Ms Grace MacDonald
Senior Planner

09/03/2022

**ESR Horsley Logistics Park-Mod-4 (SSD-10436-Mod-4)
Request for additional information**

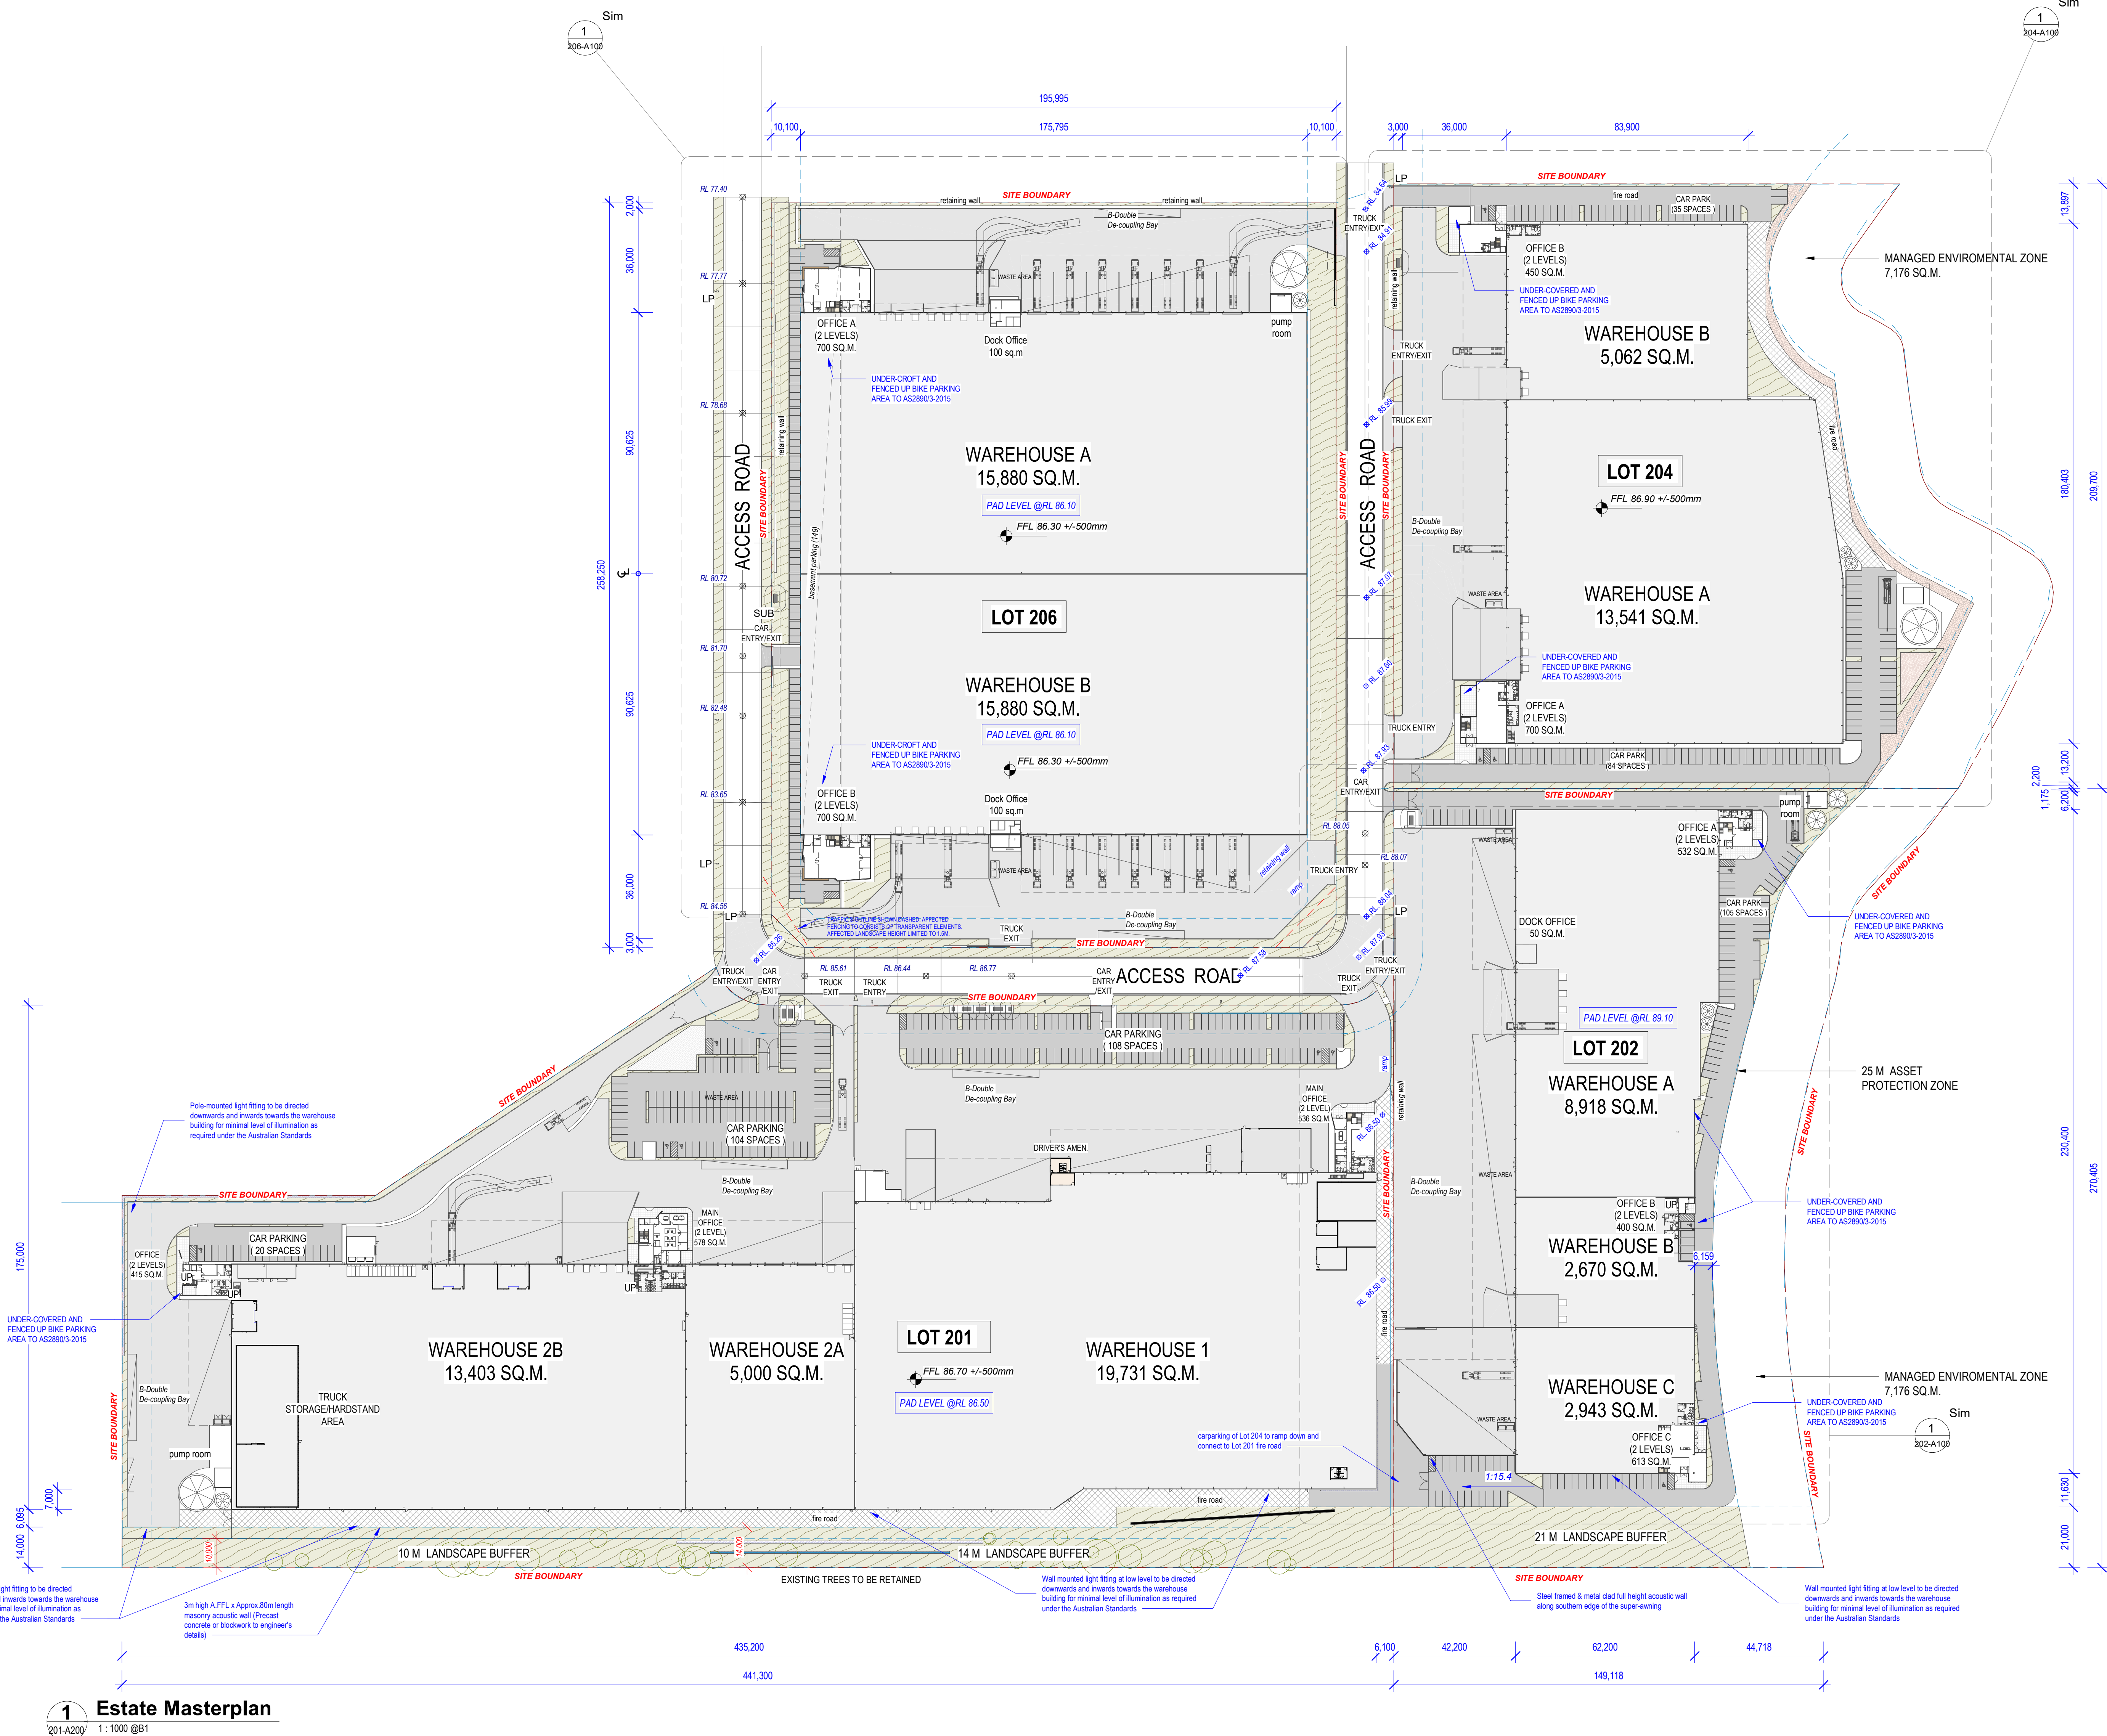
1. The proposed Lot 204 site area detailed in the current Modification Report (40,272m²) is inconsistent with Estate Masterplan within the SSD-10436-Mod 5 consent (40,295m²). Please clarify why there is a 23m² difference in the Lot 204 site area.
2. Section 3 of the Modification Report states that the proposal incorporates a reduction in the GFA for Lot 204. This is inconsistent with Section 4.4 of the Modification Report which details an increase in the overall GFA for Lot 204 compared to Mod 2. Please clarify this discrepancy.
3. An updated Estate Masterplan detailing all proposed changes to Lot 204 is required.
